Our Ref: M-01042556

20 February 2023

**PROPOSED DEVELOPMENT CONSENT ORDER (DCO)  
IMMINGHAM GREEN ENERGY TERMINAL (IGET PROJECT)  
REPRESENTATIONS IN RESPONSE TO CONSULTATION EXERCISE**

Drawing Title: **PROPOSED SPEED LIMIT CHANGES ALONG LAPORTE ROAD SHEET 1 OF 1**

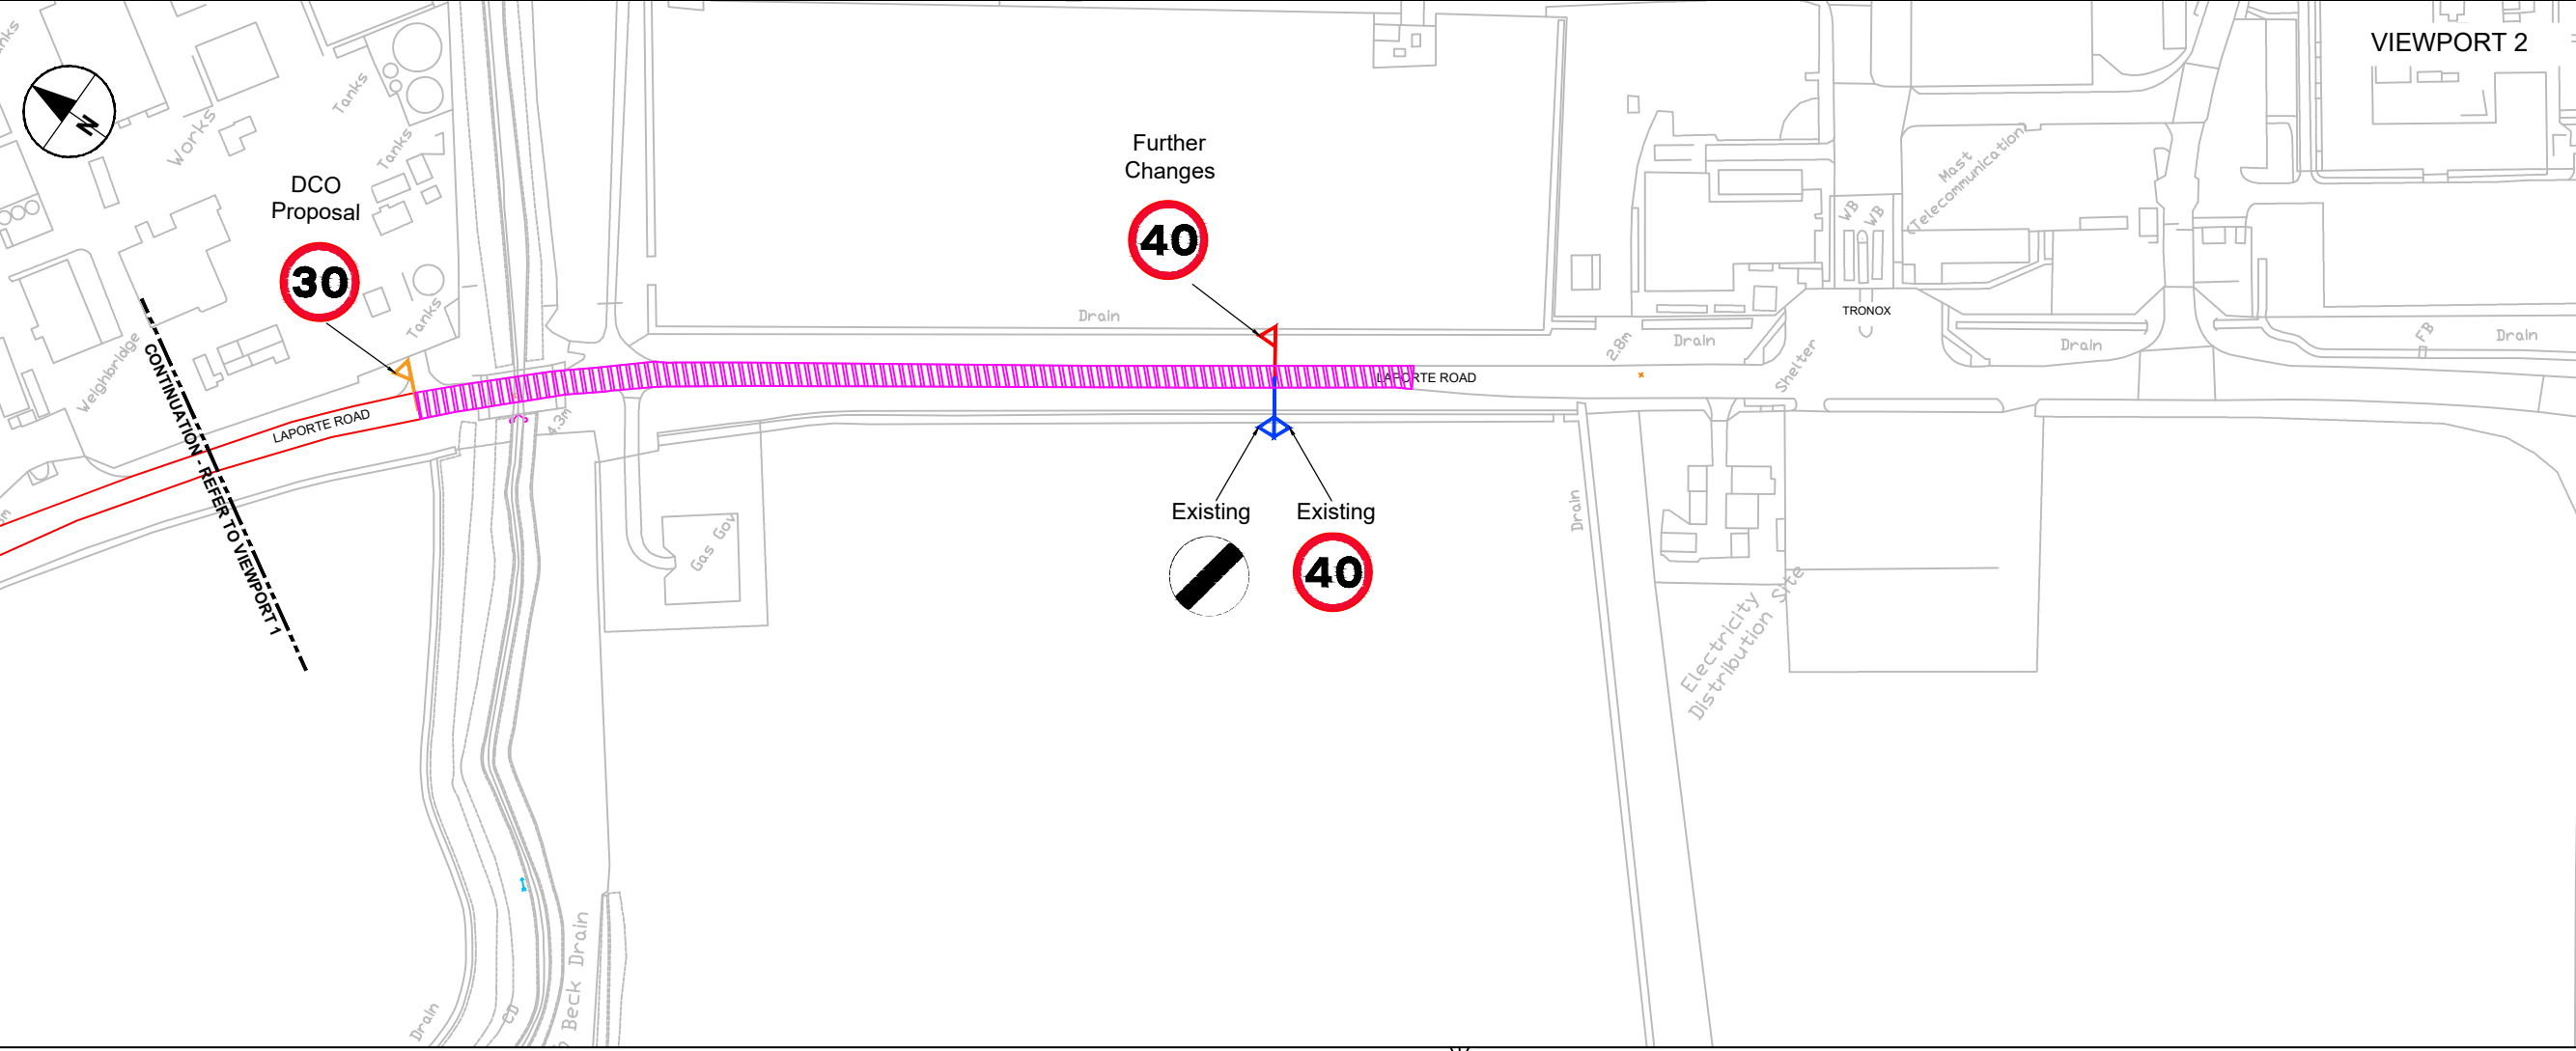
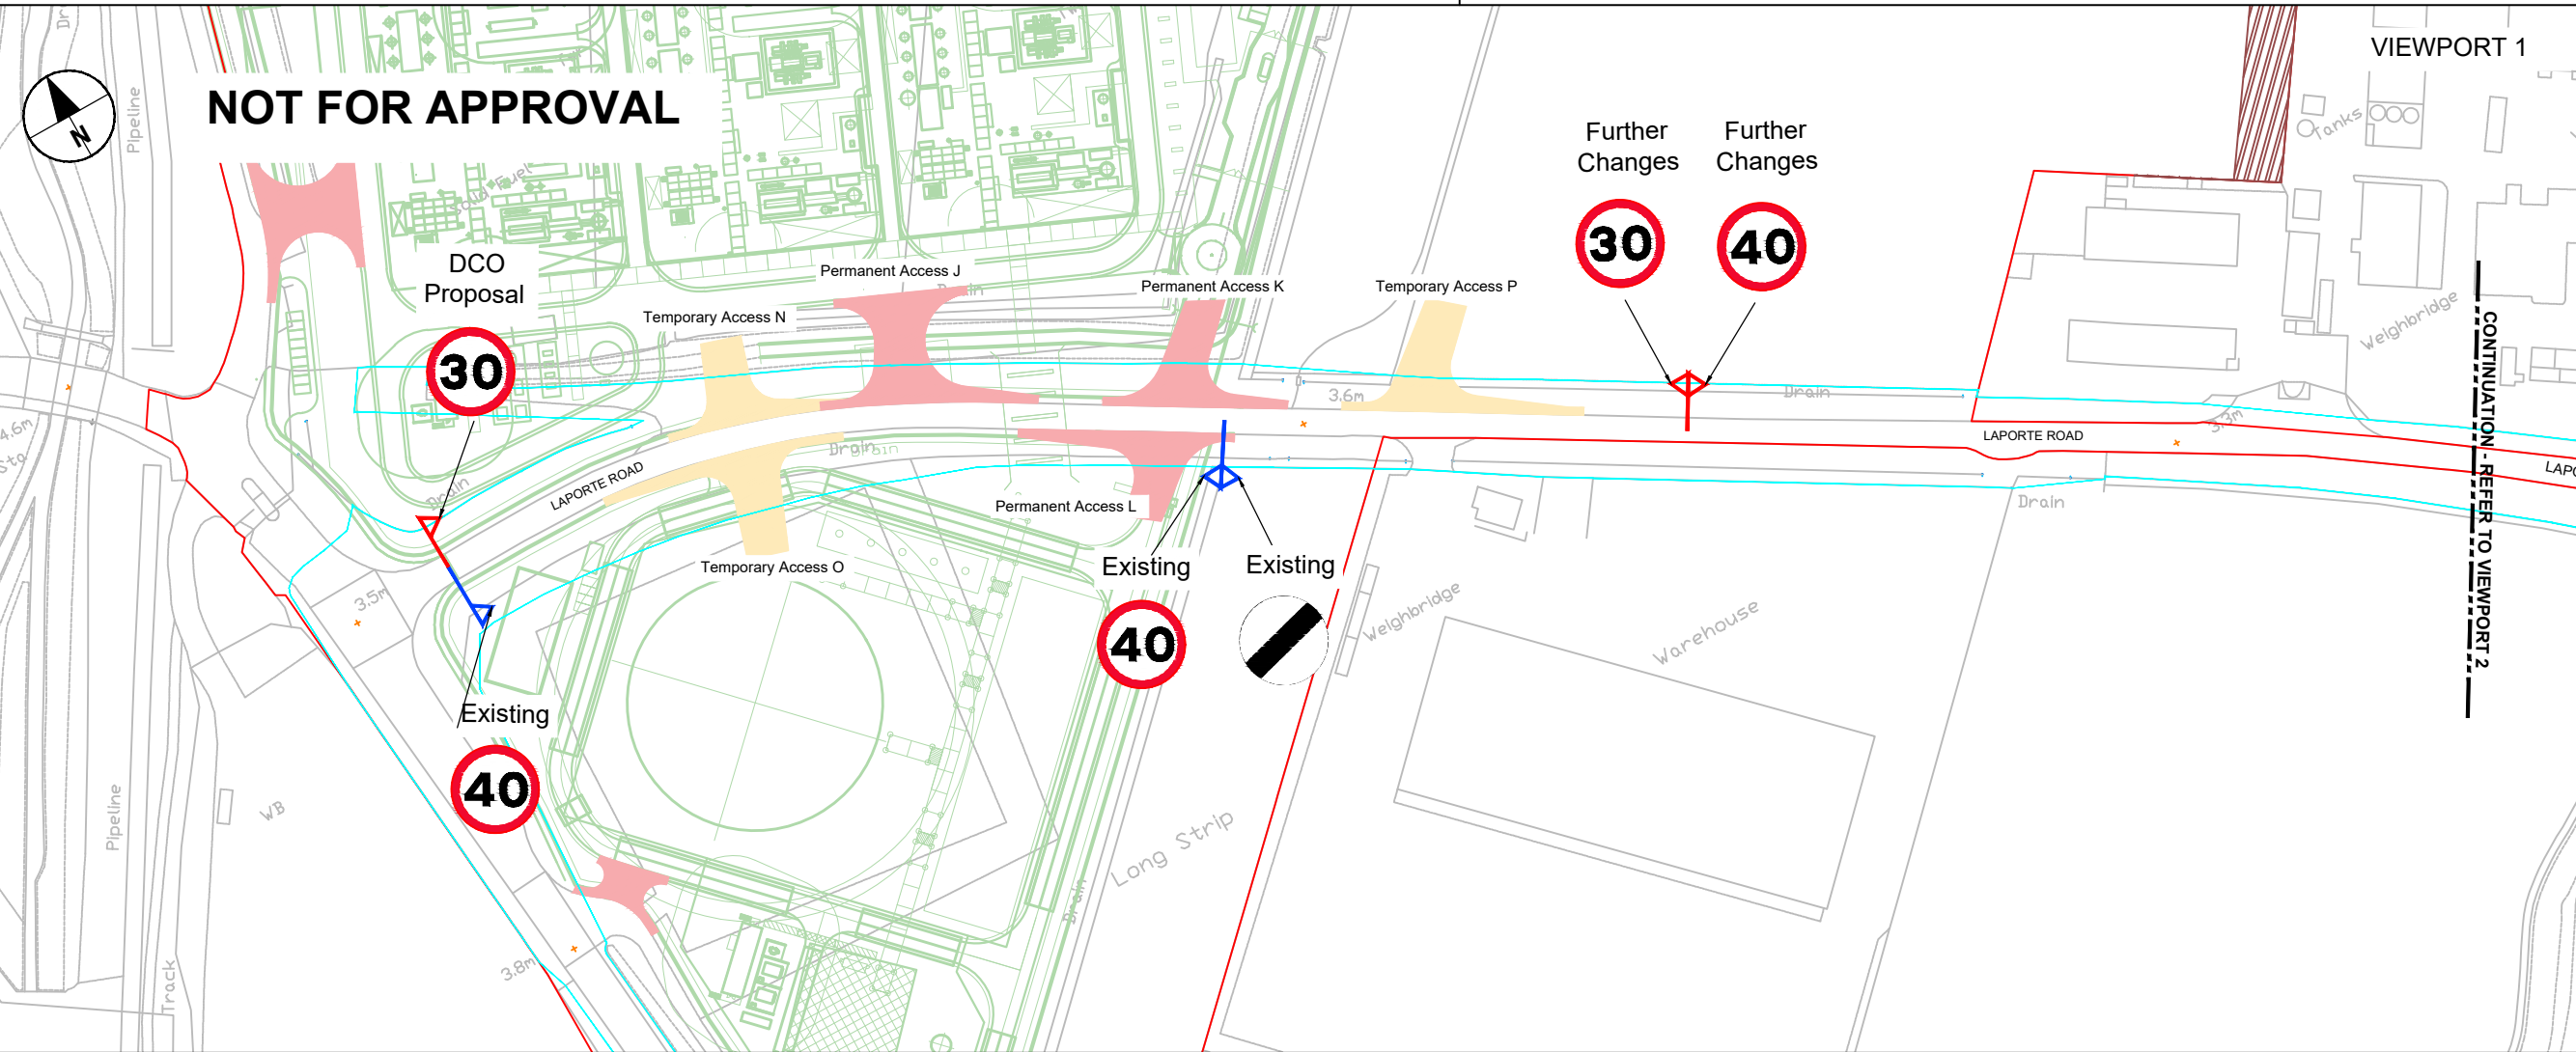
Of further concern is the fact that this increased traffic will comprise a considerable number of HGV movements. As noted, Laporte Road is already a very busy highway being the main access point to the docks at its junction with Queens Road. The proposed access point to the temporary construction compound is circa 200 yards from the entrance to our Plant. We have many HGVs making deliveries to the Plant daily. With no middle right hand turning lane, and limited space at the entrance to our Plant, there are already occasions when the traffic has needed to queue to access the site, leading to a number of near misses in the past with HGV's waiting to gain entry. Increased traffic flow during the construction phase of the IGET Project has the potential to exacerbate this problem and it is not unforeseeable that the queues from the junction with Laporte Road and Queens Road during rush hour could back up to the Plant entrance, restricting access for deliveries, employees and visitors. It is unclear whether any investigation of the potential to use the port to deliver construction materials etc necessary to deliver the scheme has been explored as an alternative measure to reduce/minimise vehicle movements on the local highway network.
